FDR:

GRADING & EROSION CONTROL PLAN
CLAREMONT BUSINESS PARK FIL. NO. 1A, LOT 2
JOB NO. 44-034
DATE PREPARED: JANUARY 2, 2019
DATE REVISED: SEPTEMBER 11, 2019

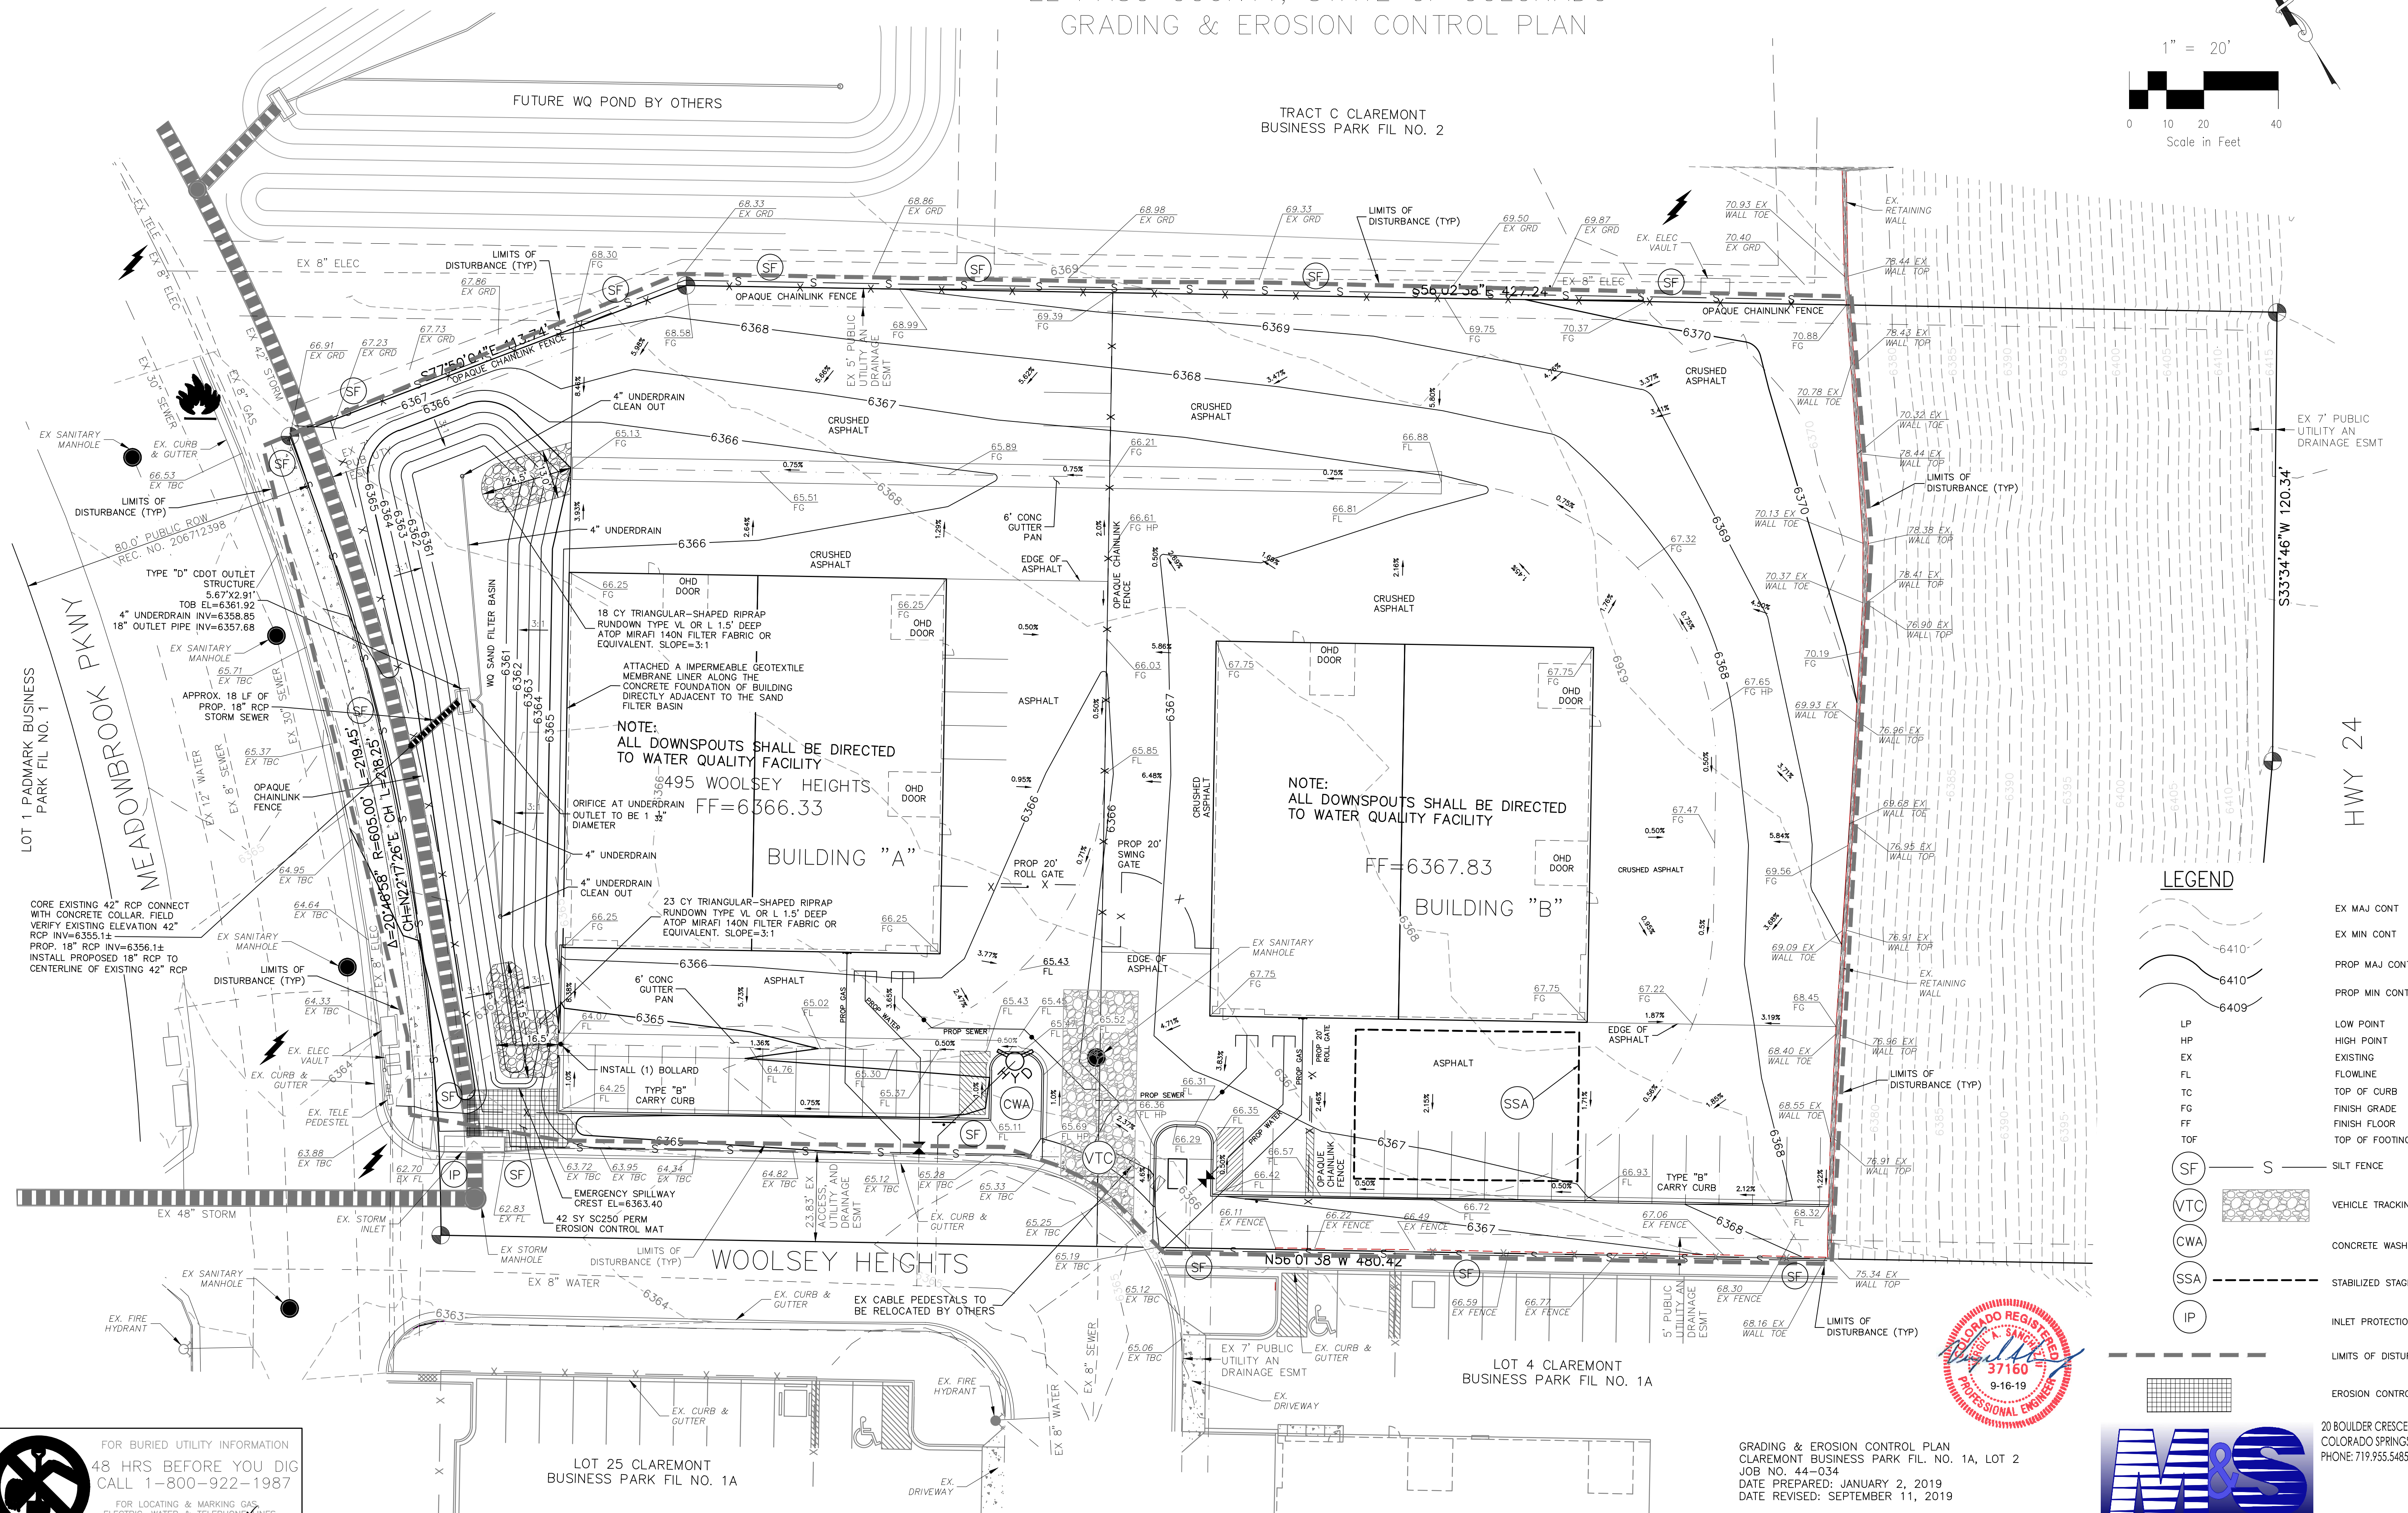
In general the FDR is confusing with the nomenclature used where you call the site "Claremont Business Park filing no 2, lot 2-1A. The site is platted as "Lot 2, Claremont Business Park filing No. 1A" or "Claremont Business Park filing No. 1A, Lot 2". Please correct this reference at all locations.

***The title of the project has been revised throughout the GEC plans and FDR report to "Claremont Business Park Fil 1A, Lot 2".***

CBP LOT 2-1A
PROPOSED DRAINAGE MAP

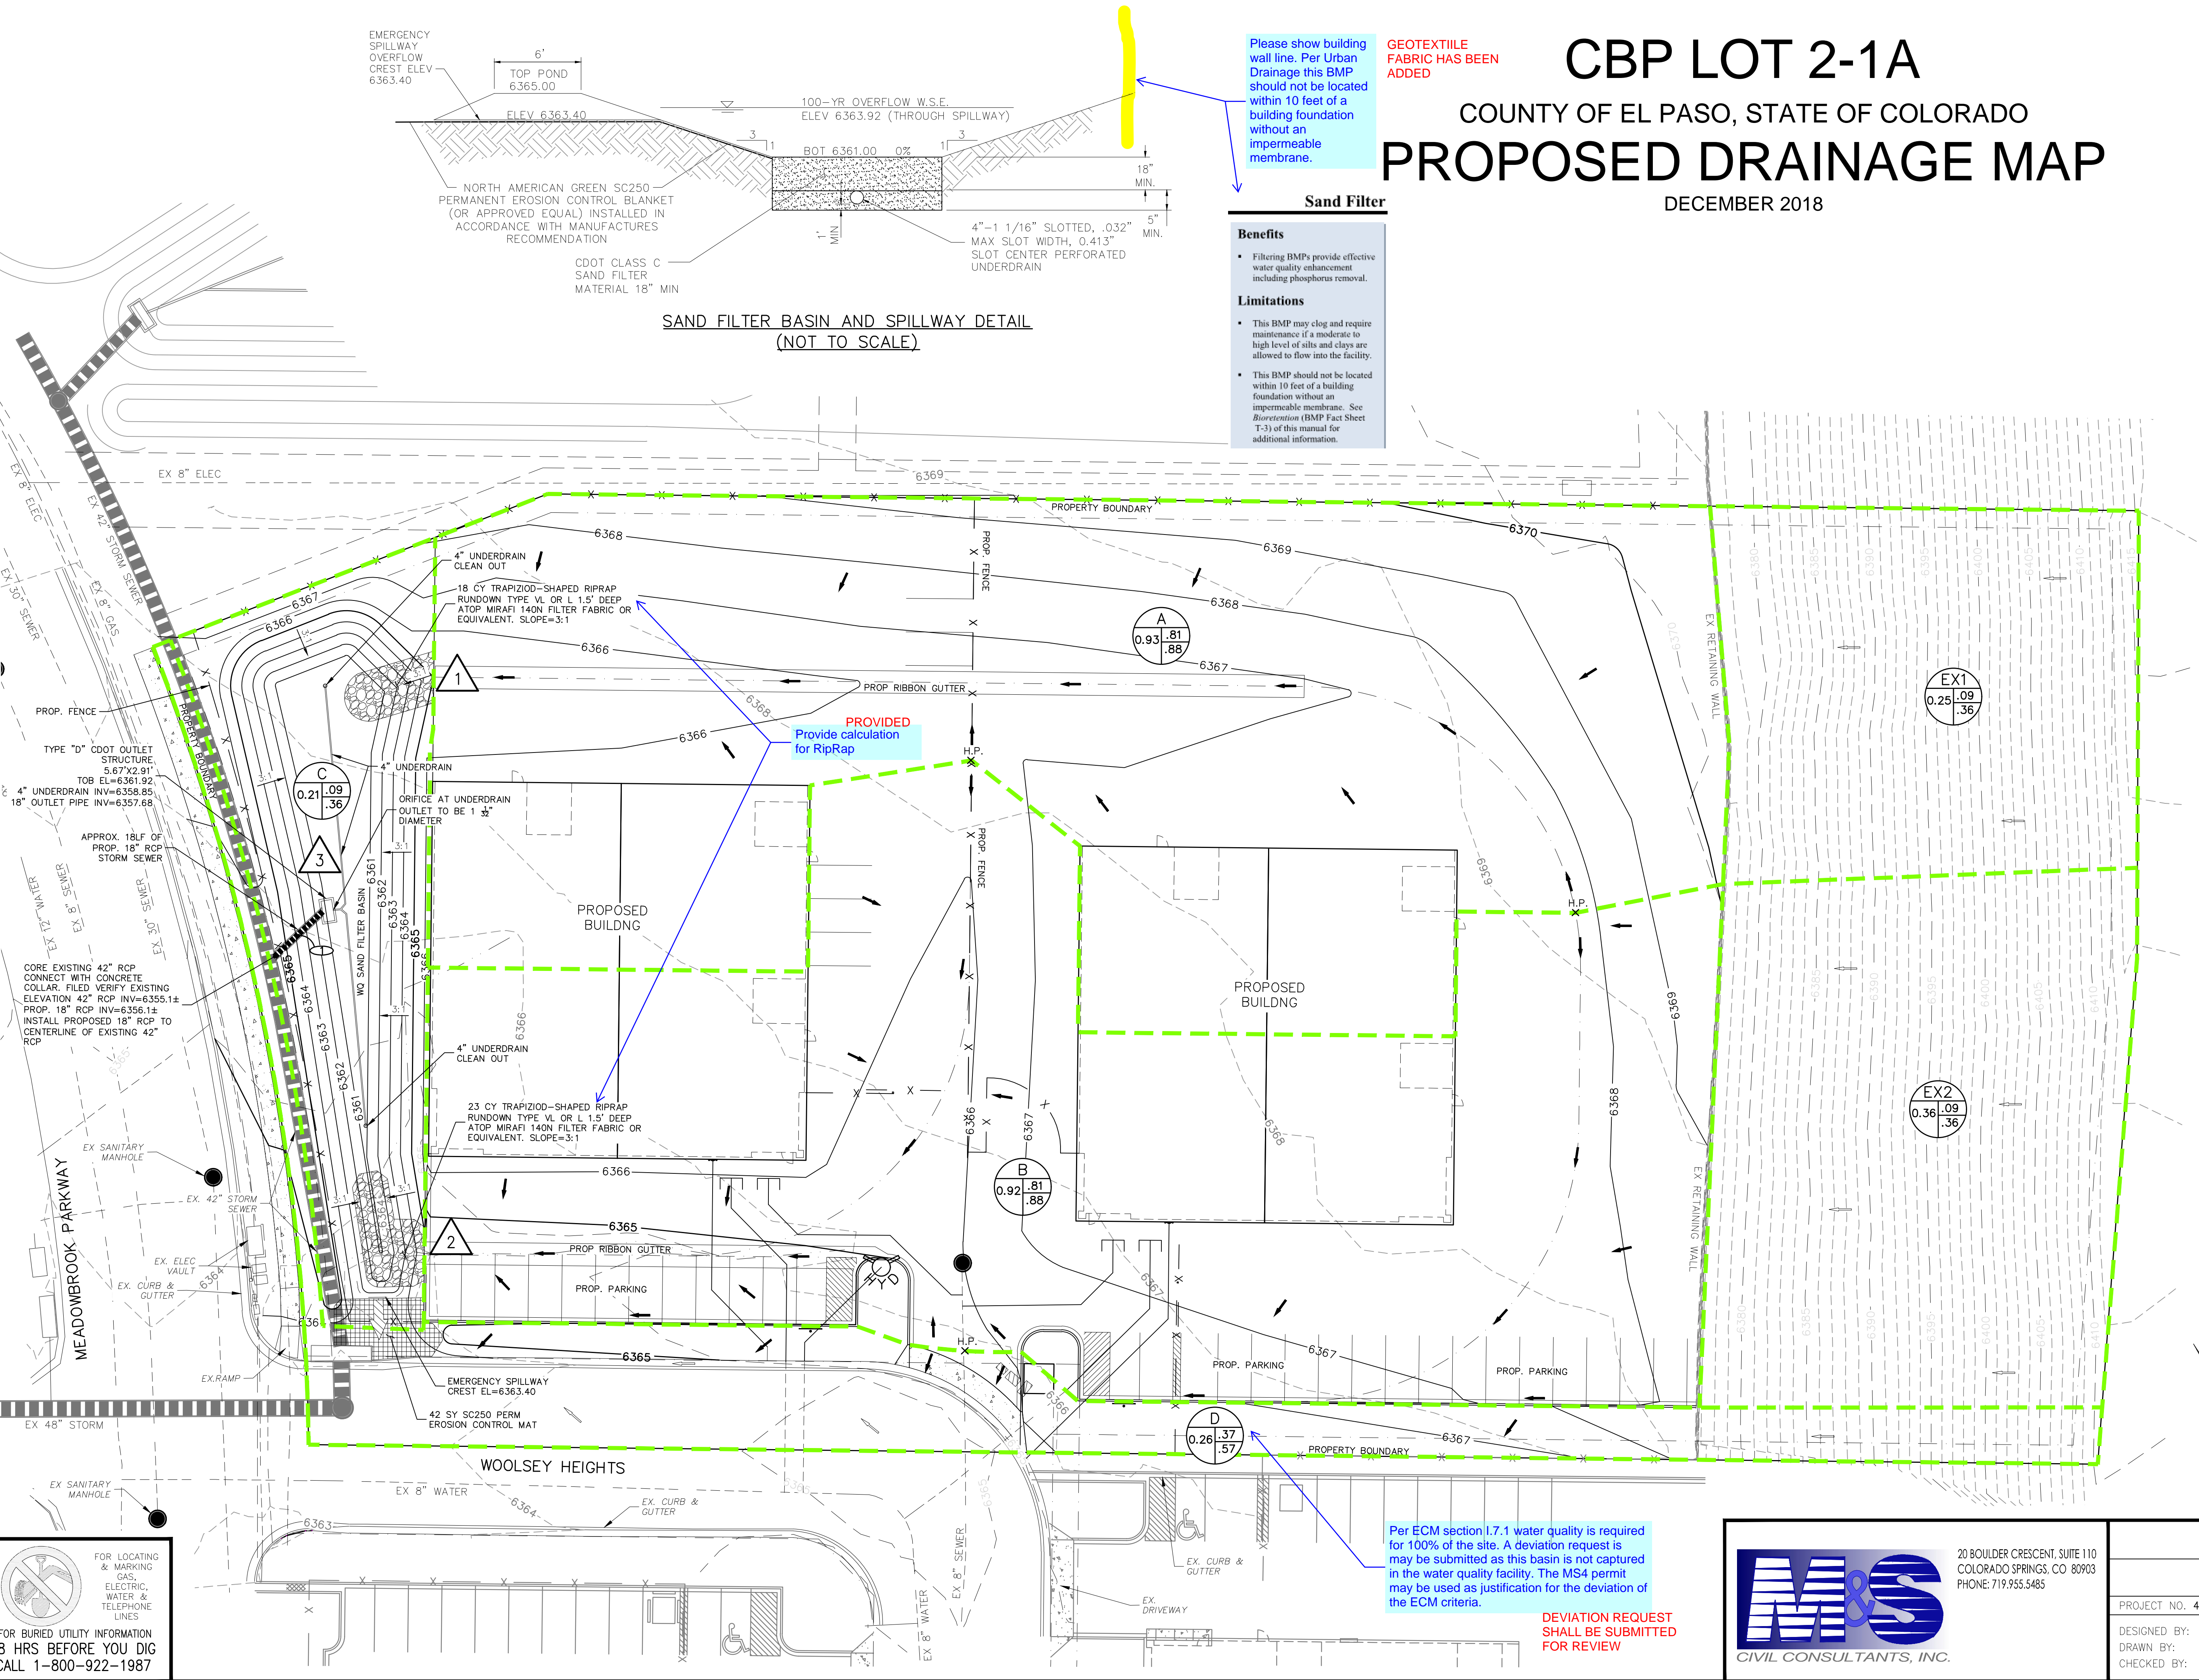
Please explain how you got a weighted C value for basins A and B when the basins are 100% impervious. Please update all calculations (for each basin) for the weighed C and provide a single weighted C for the entire site, and (as stated above) compare to the previous reports assumptions.

***The C Value in question has been decided to be left as originally determined in the report.***
